CITY OF ALBUQUERQUE

Re: Unser Crossing- Building A
10550 Unser Blvd NW
Request for Certificate of Occupancy-30 Day Temp
Transportation Development Final Inspection
Architect's Stamp date 7-20-21 (A11D017B)
Certification dated 2-27-24

Re: Unser Crossing- Building B
10550 Unser Blvd NW
Request for Certificate of Occupancy-30 Day Temp
Transportation Development Final Inspection
Architect's Stamp date 7-20-21 (A11D017B)
Certification dated 2-27-24

DATE
03-30-2021
SHEET NUMBER
AS-1.1

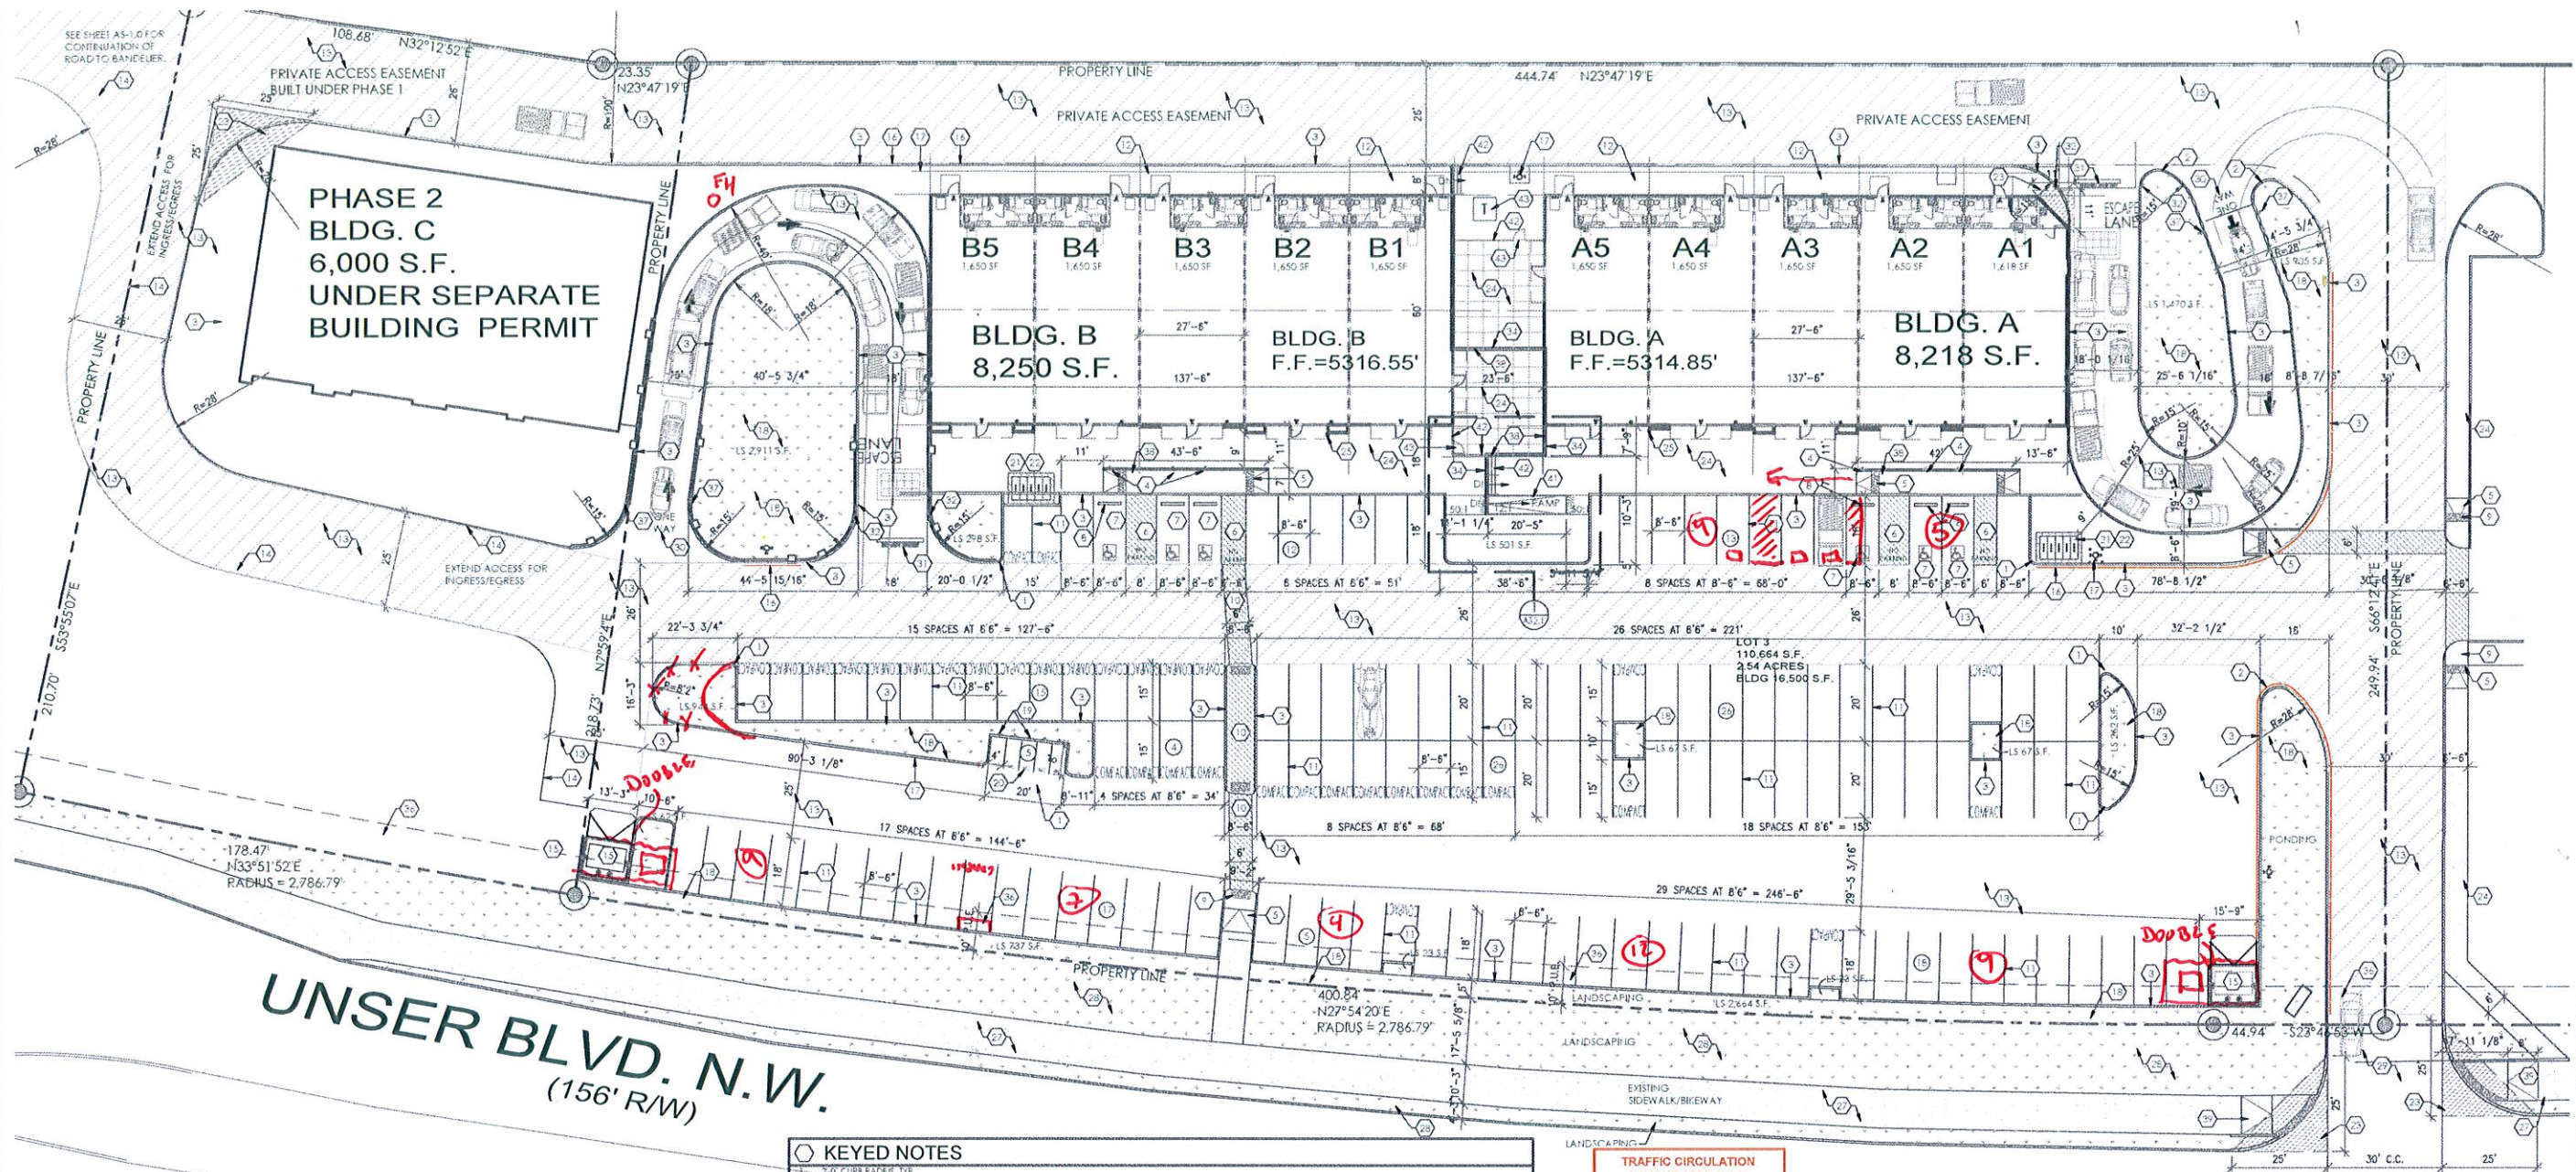
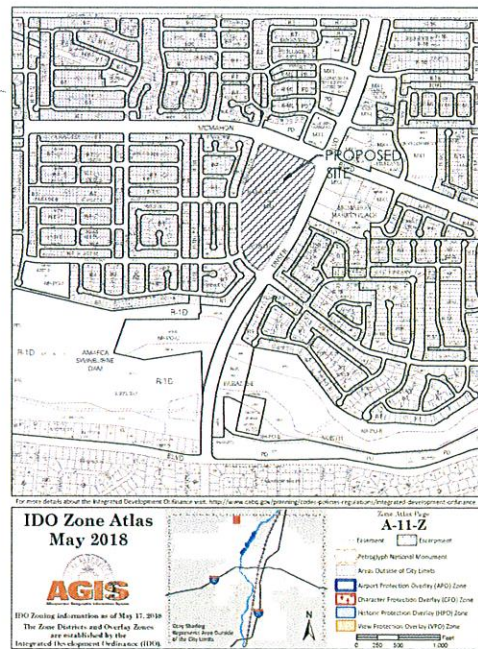
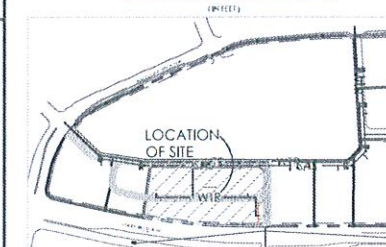
1. The installed size of each bike rack was not per plan: 14" wide.
2. The installed spacing between bike was not spaced per plan: 16" apart.

1. The installed size of each bike rack was not per plan: 14" wide.
2. The installed spacing between bike was not spaced per plan: 16" apart.
3. The drive-up was missing the "Do Not Enter" and One-Way" pavement markings.
4. The asphalt at the south edge of the site, east of the drive through, terminated into uneven dirt with piles of concrete and asphalt debris and the asphalt drive through the area labeled "Phase 2 Bldg C" was not constructed.
